**Subject:** 2025/62/93355/E Land off Woodward Court

## **OBJECTION TO PLANNING APPLICATION FOR ERECTION OF 75 RESIDENTIAL DWELLINGS WITH ASSOCIATED LANDSCAPING, OPEN SPACE, HIGHWAYS AND DRAINAGE INFRASTRUCTURE**

**LAND OFF, WOODWARD COURT, MIRFIELD, WF14 0PY**

**LPA REF: 2025/93355**

--- 2.4M X 25M JUNCTION VISIBILITY SPLAY BASED ON 20MPH SPEED LIMIT

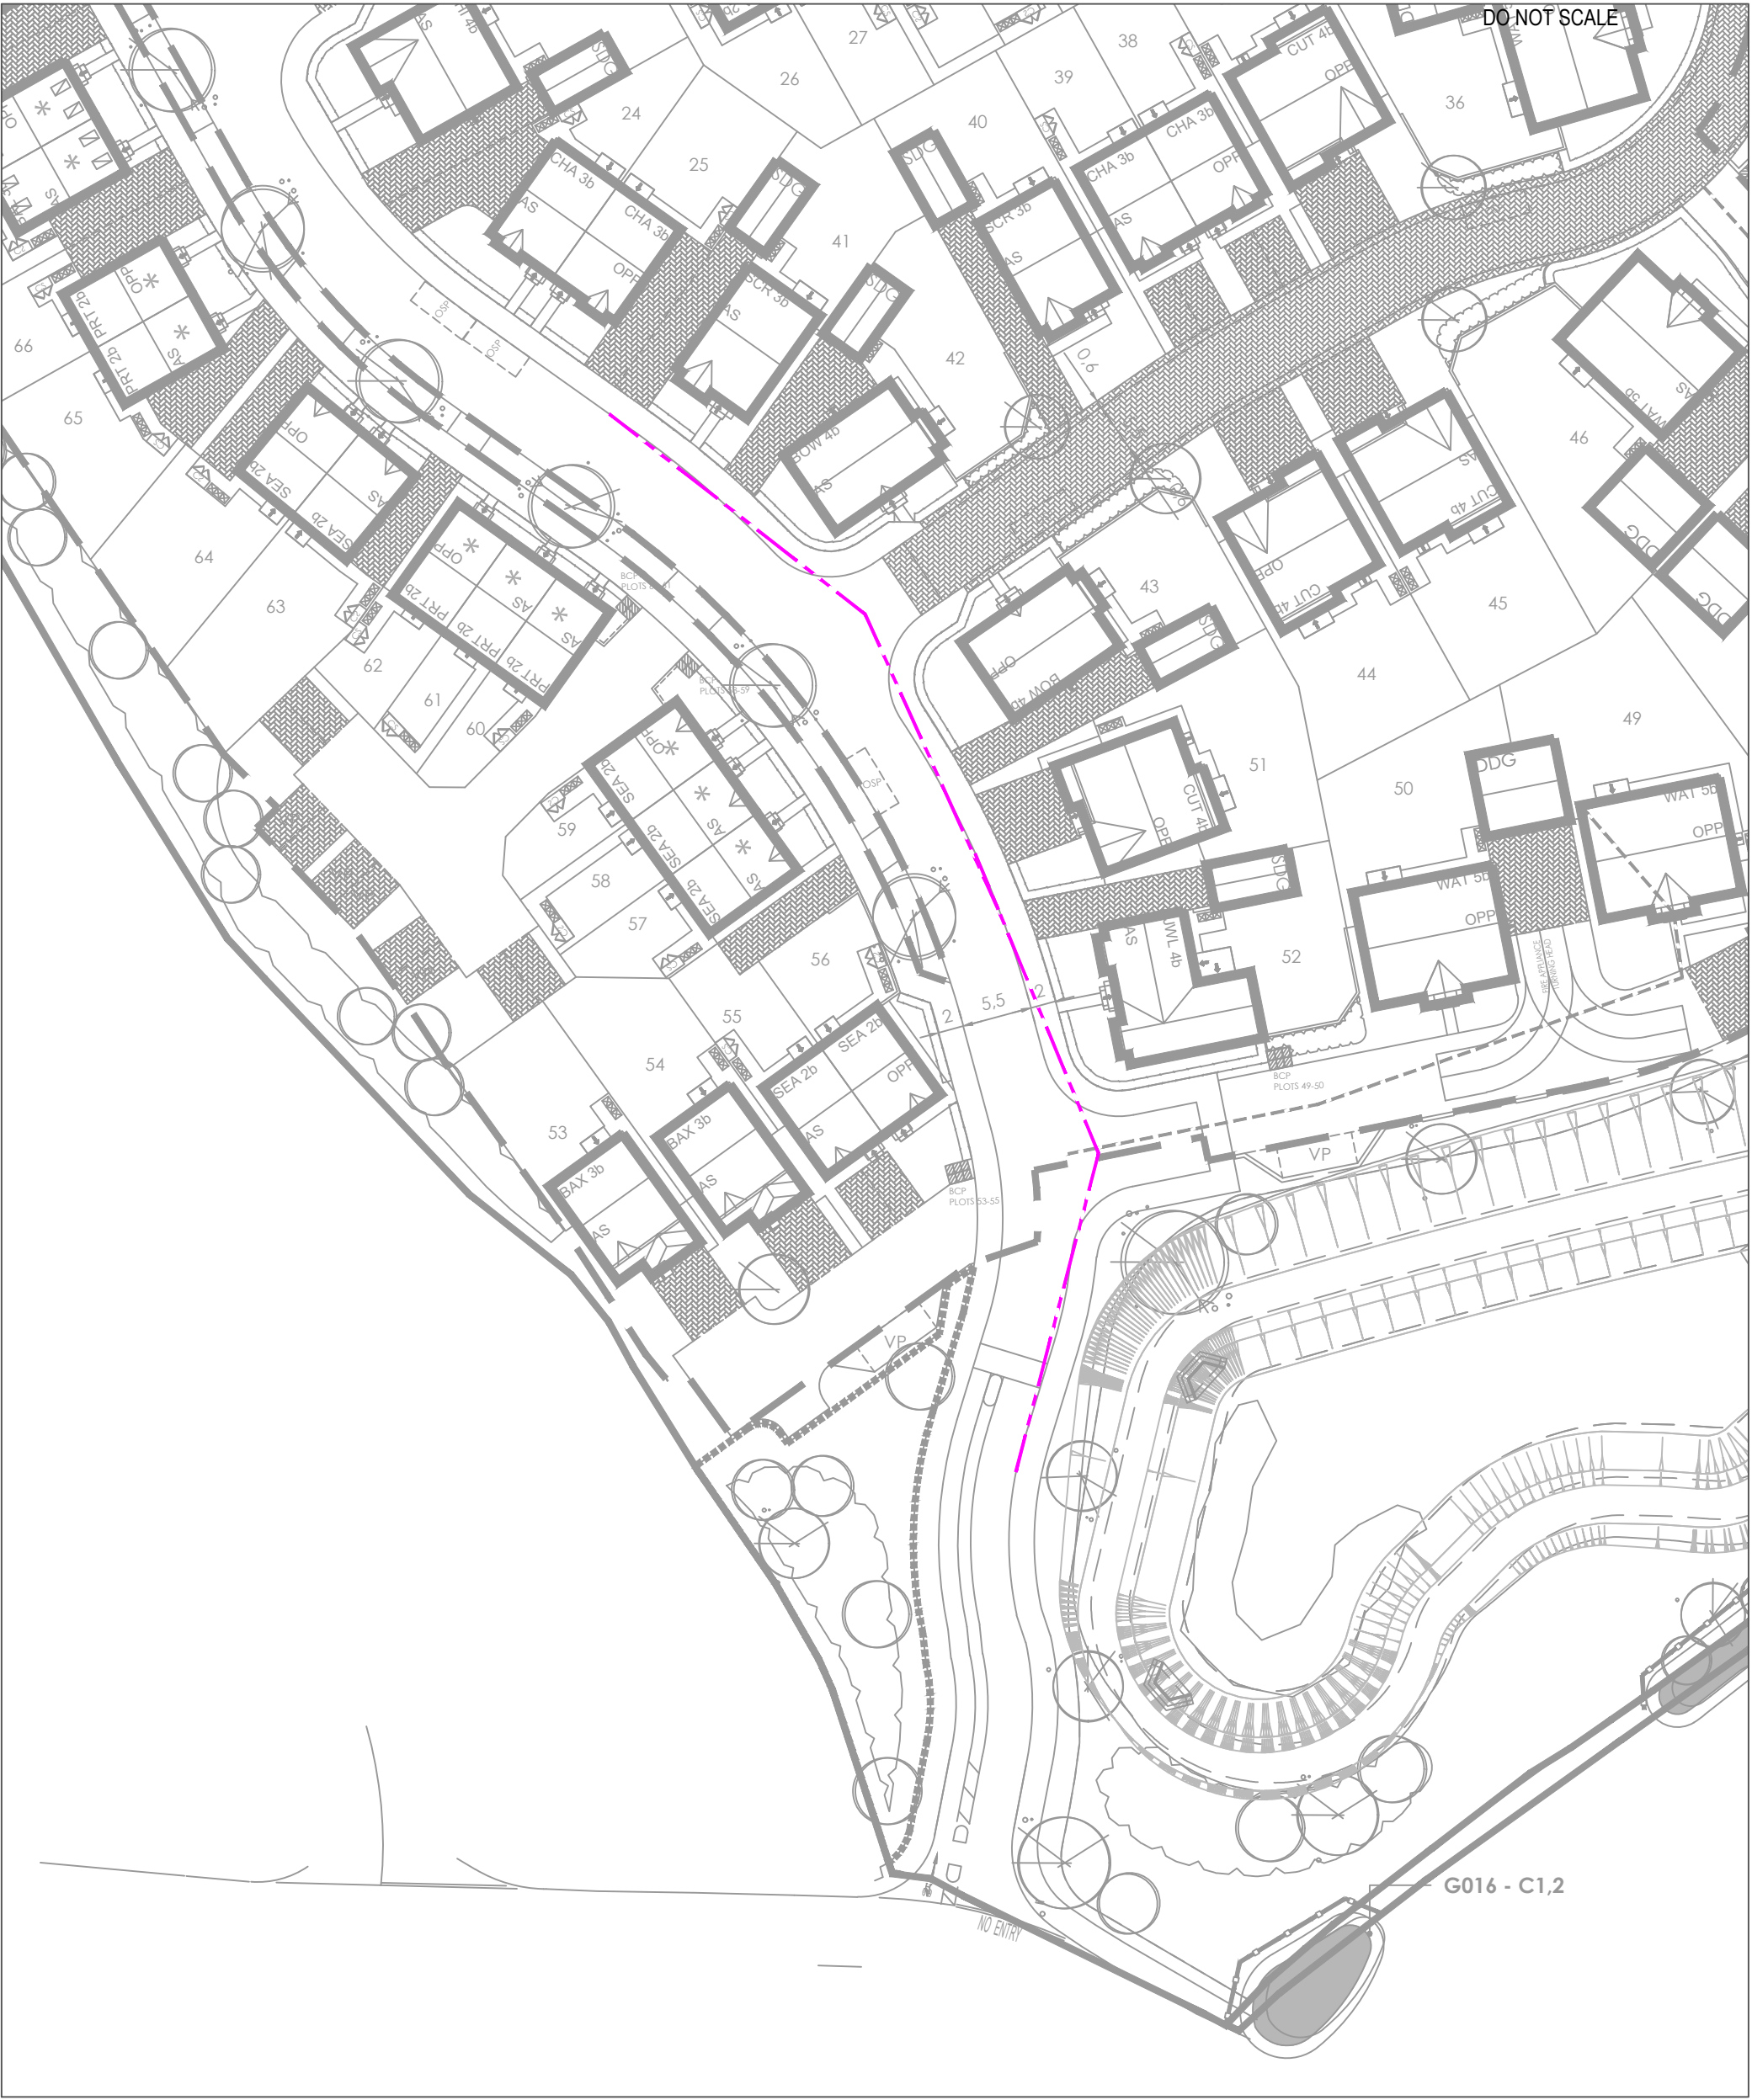
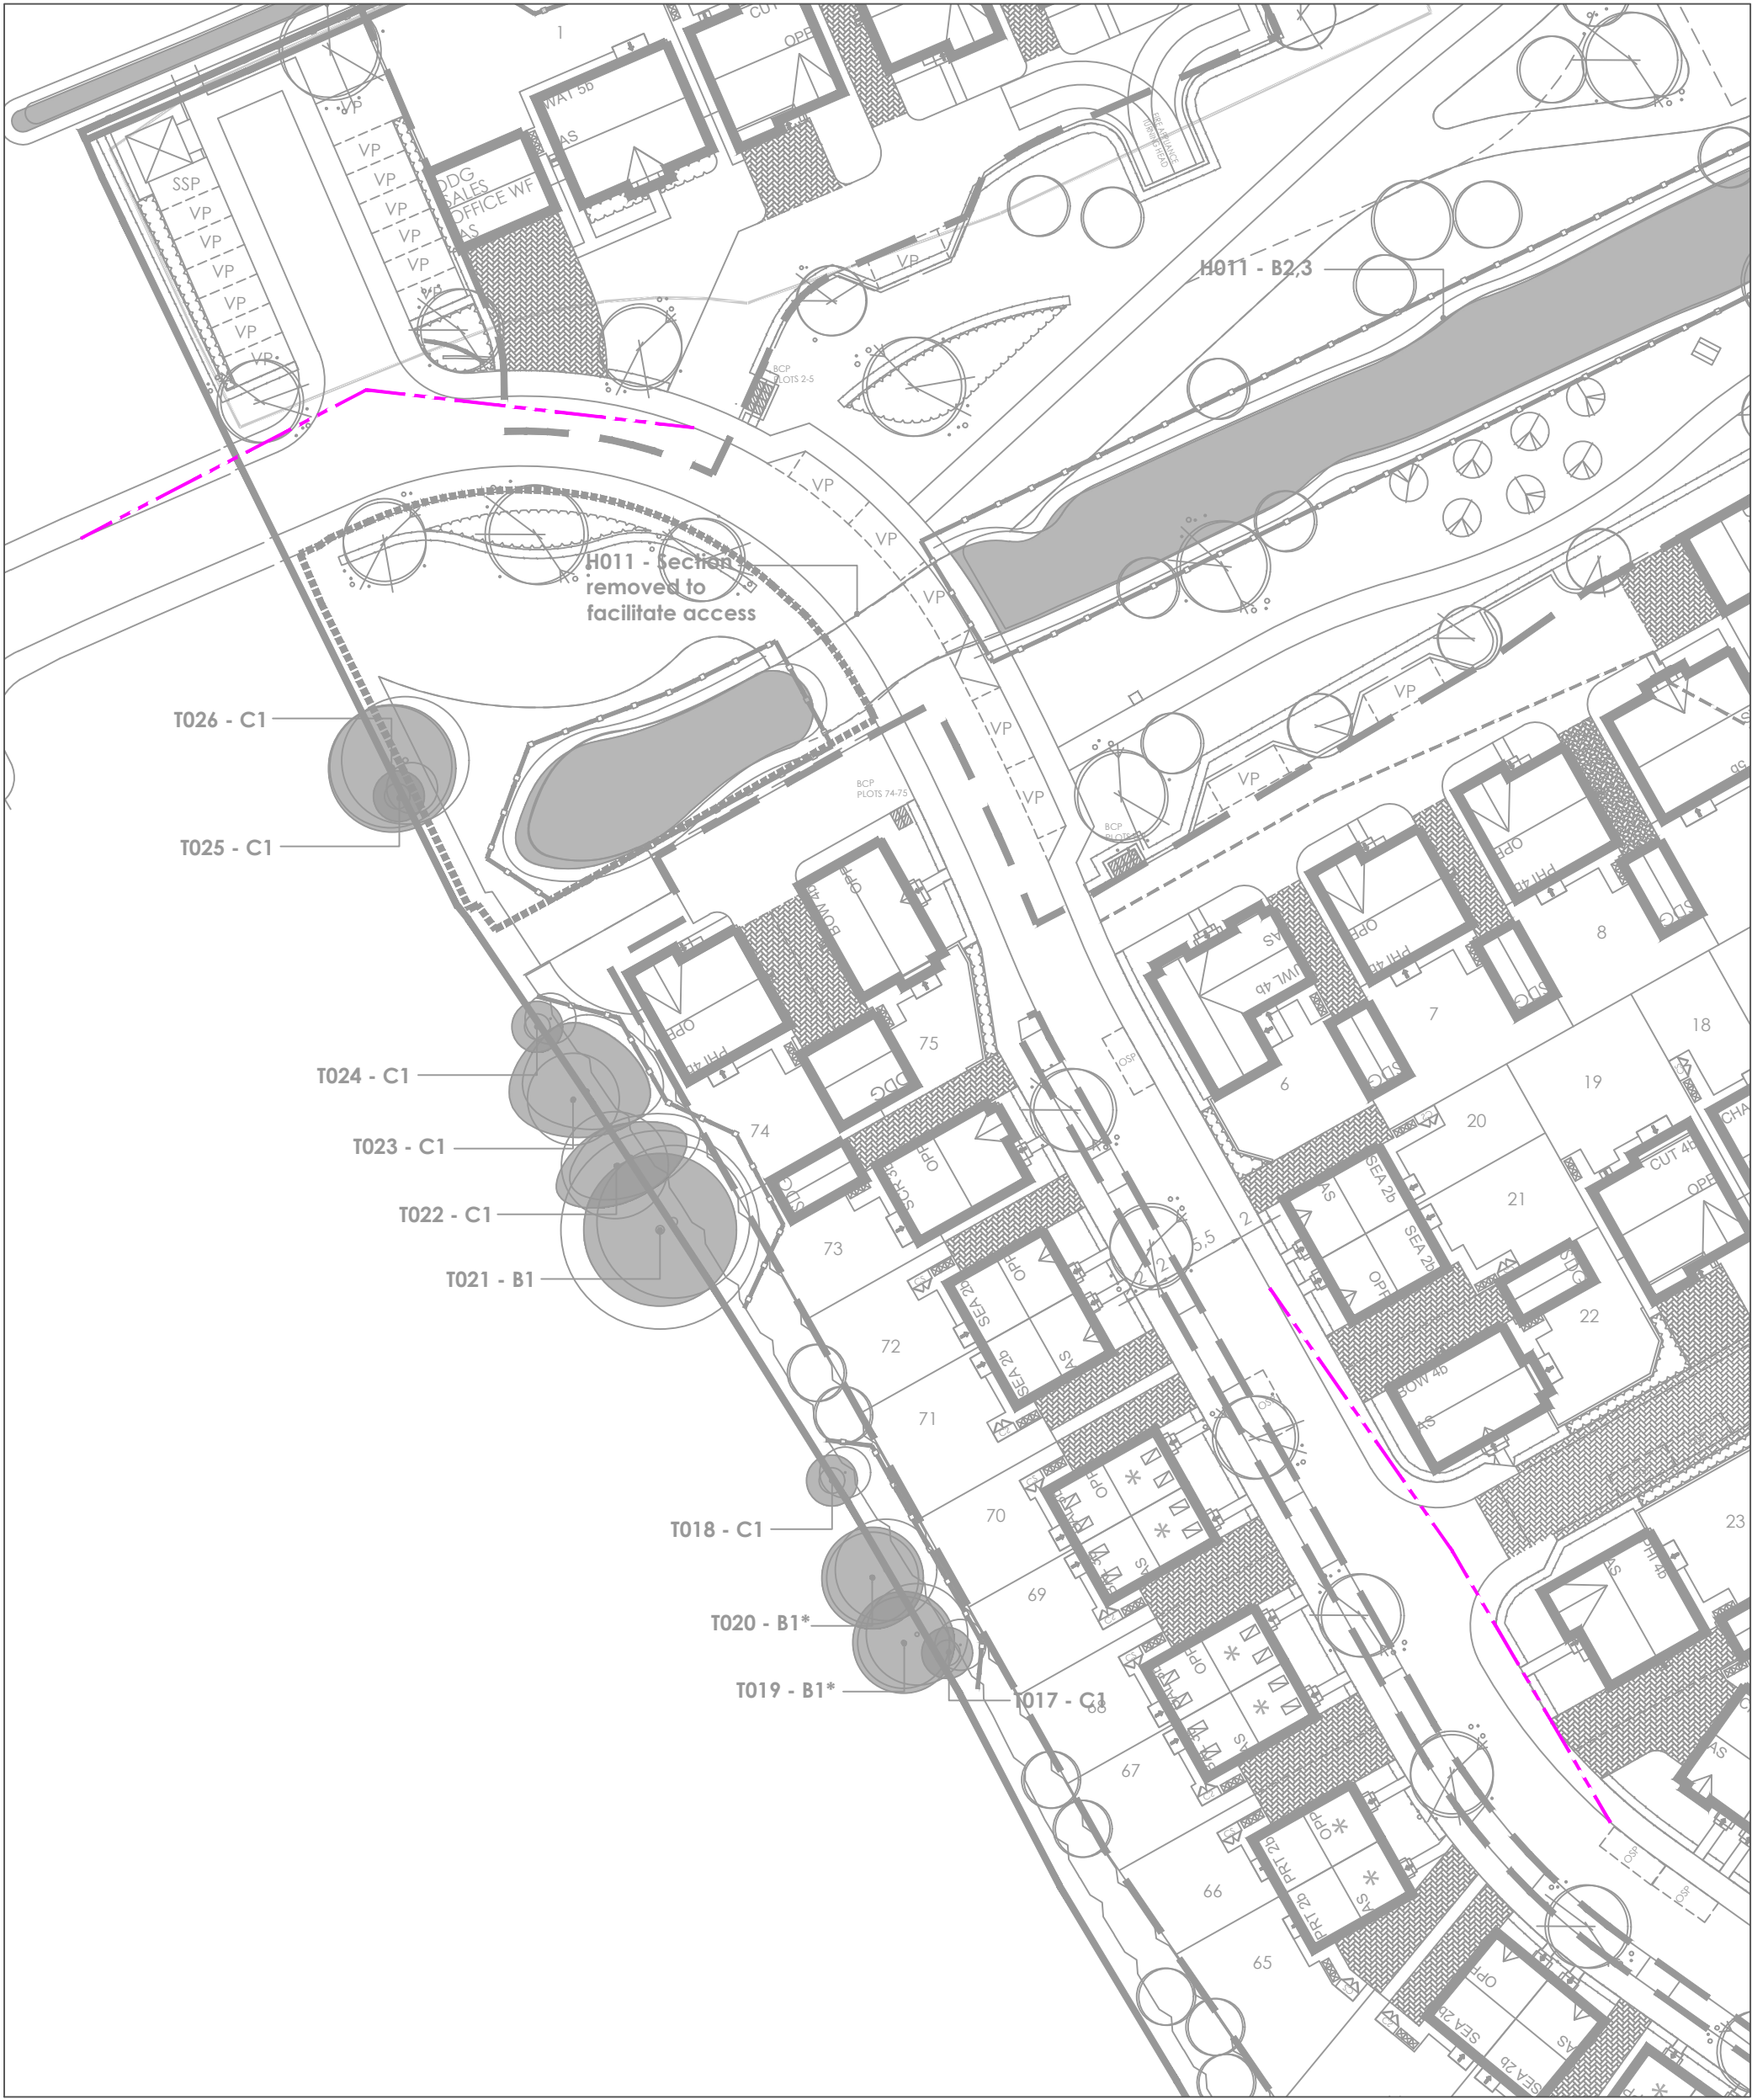
**Response:** Instead of securing the third party land to ensure safe visibility splays in accordance with the speed limits at the Woodward Court junction (as highlighted was necessary in the Kirklees Rejected Site Options report – see below), the proposals instead introduce highway measures on the existing road network, such as traffic calming (also previously rejected by Highway Services in 2014 as highlighted above). These measures however do not amount to ‘improvements’, but instead are a series of measures designed not to improve the highway, but introduce obstacles to make the development and its highway impact ‘appear’ acceptable.

Overall therefore, there are no concrete proposals to enhance the safety or capacity of any surrounding roads in terms of suitable widths, footway provision, geometry etc. There are no proposals to secure the third party land necessary to enable safe visibility splays to be provided at any of the junctions likely to see impacts from the development, in particular the Woodward Court / Wellhouse Lane junction.

*Sufficient junction visibility can be achieved to the north for drivers leaving Woodward Court, in accordance with MfS for the recorded 85th percentile speed of 24.6mph i.e. a 2.4m x 30.2m. Visibility along Wellhouse Lane to the south for vehicles departing Woodward Court is restricted when measured to the nearside kerbline with an achievable splay of 2.4m x 29.3m (assuming any vegetation overhanging the rear of the footway is cut back). A 29.3m visibility splay is less than the 40m required in accordance with MfS for the recorded 85th percentile northbound speed of 30.0mph.*

- 1) The applicant appears to be relying on vegetation being cut back on third party land in order to achieve its stated visibility splay. This is an absurd proposition and cannot (as the applicant knows) be taken into account when assessing serious highway safety matters where people's lives are potentially at stake. The fact therefore remains that suitable and safe visibility splays cannot be achieved by this development at this junction (see photo overleaf which demonstrates that significantly less than 29.3 m can be achieved - meaning that this junction will remain unsafe, and its use intensified, through this proposed development).
